8<sup>th</sup> October 2010

Re:- 69 Northaw Road East, Cuffley, Herts EN6 4LY  
Erection of Single Storey Outbuilding for use as Gym/Sunroom  
Planning Consents S6/2009/1178/LU & S6/2009/1922/FP

Drawing N°: ELA/6 Rev: 01

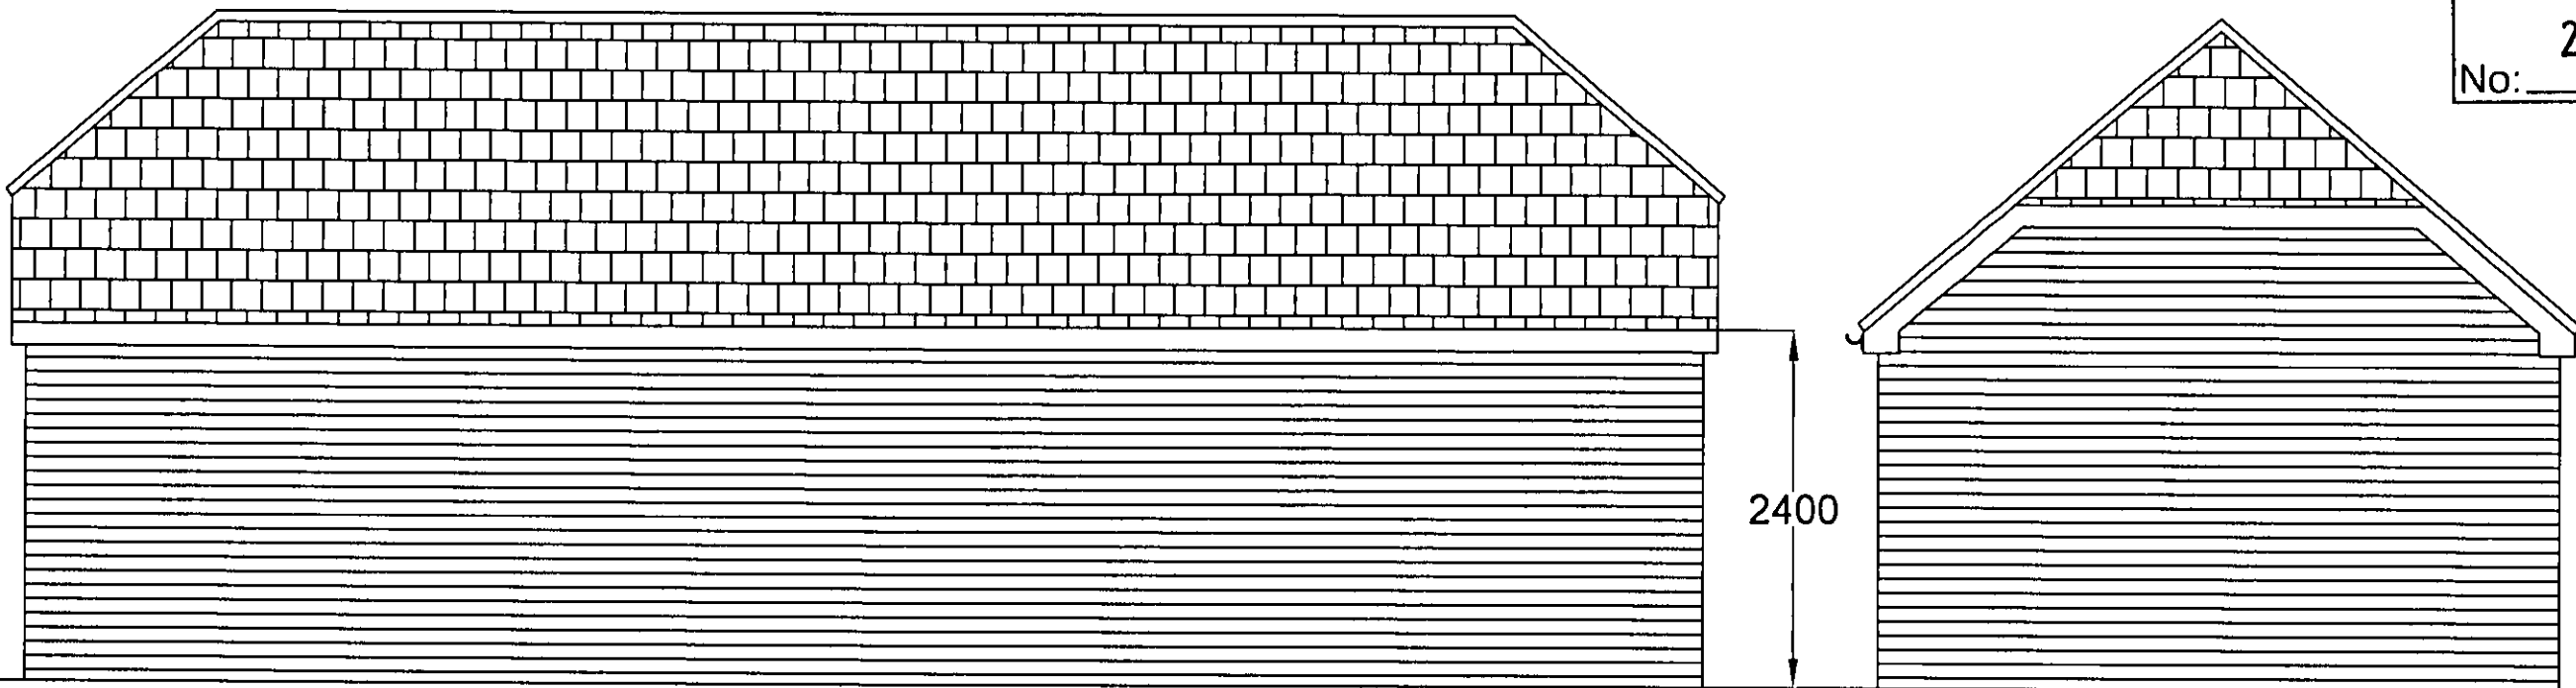
To achieve the correct lines for the design, I have made a modest increase in the height of the roof from 4.0m to 4.5m. I have also changed the hipped ends to a Dutch Barn Hipped End. These modest changes completely change the appearance of the building to a more rural design, completely in keeping with the Cuffley area.
